CITY OF ALBUQUERQUE

**RE: Midtown Self Storage Expansion
Grading and Drainage Plan
Engineer's Stamp Date 4-19-2016 (File:H17D112)**

Based upon the information received on 4-21-2016, the above-referenced Grading and Drainage Plan is approved for Grading Permit, Paving Permit and Building Permit with the following condition:

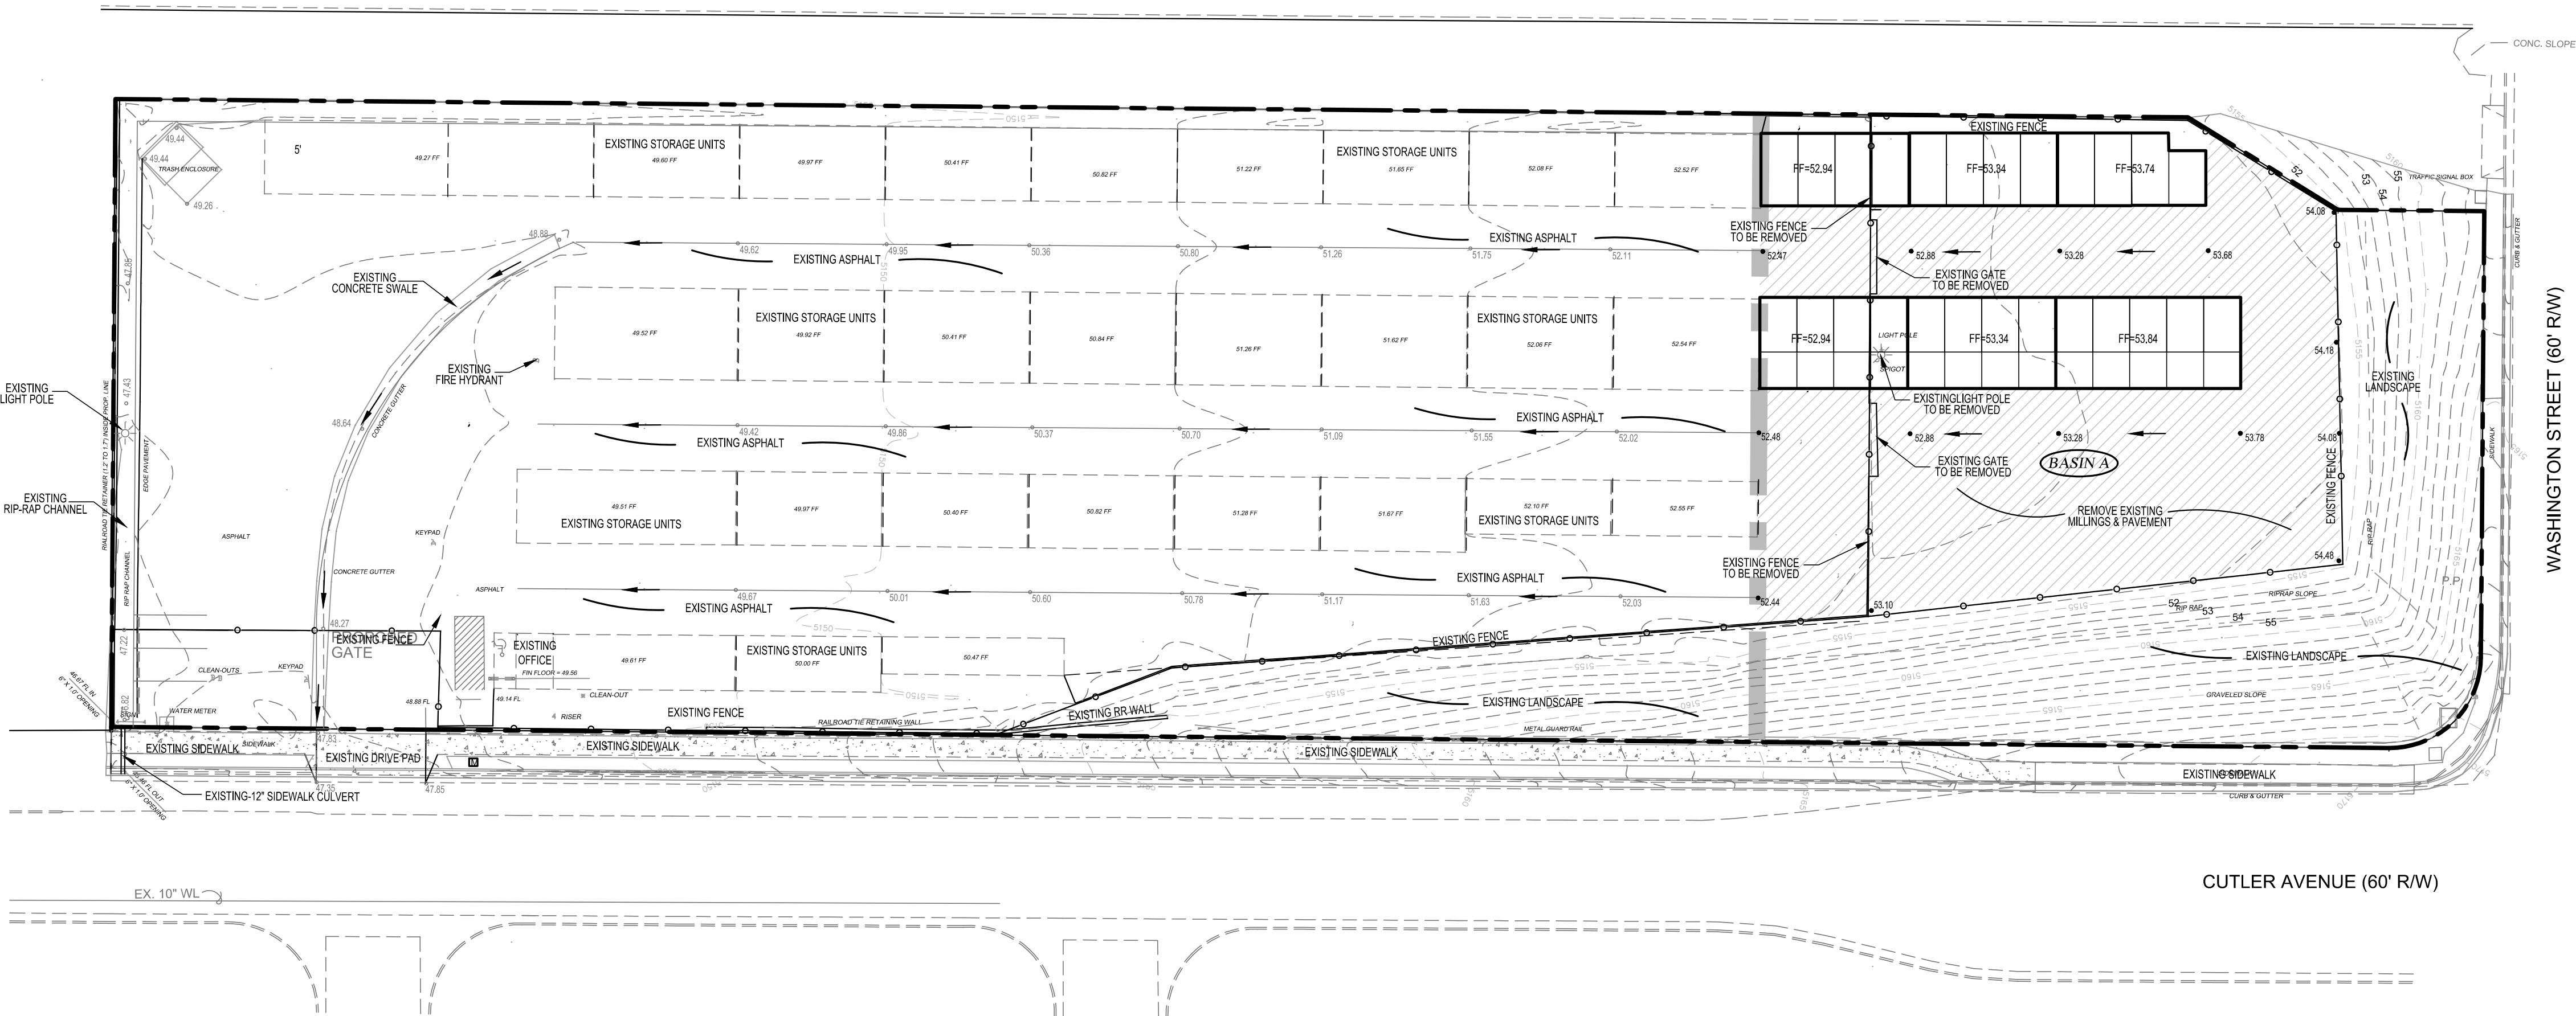
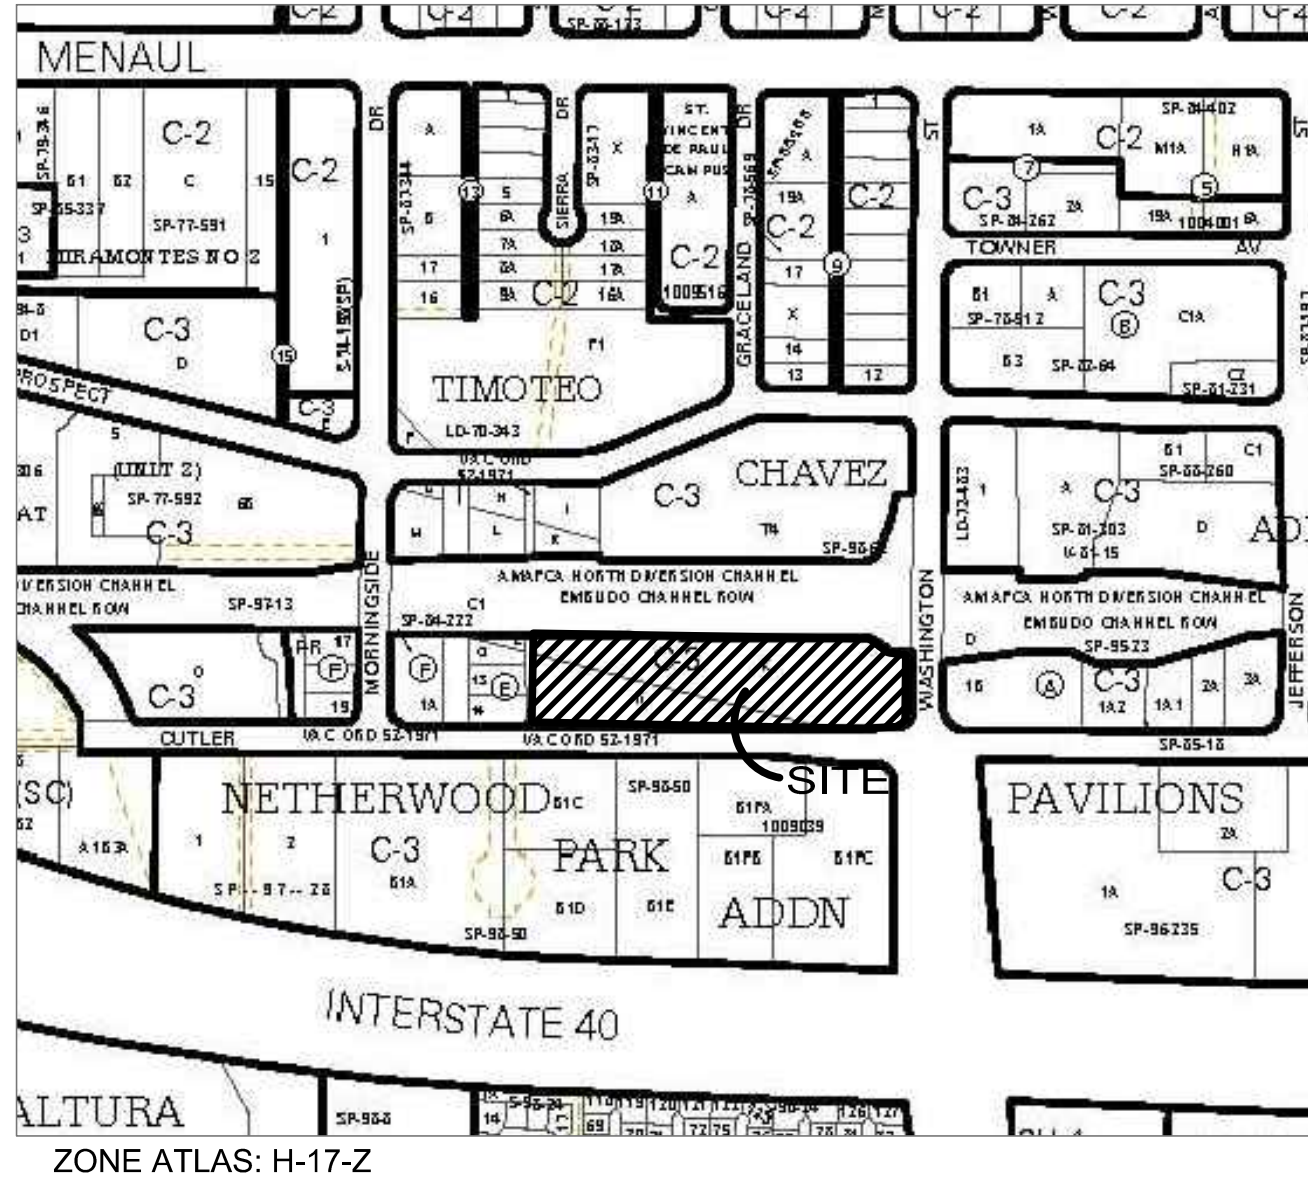
- ~~1. First flush ponding will be managed in the rip rap swale along the western edge of the property, provide dimensions and approximate volume of the pond with the Certification.~~

Condition met w/ submittal dated 6/6/16. AC 7/12/16
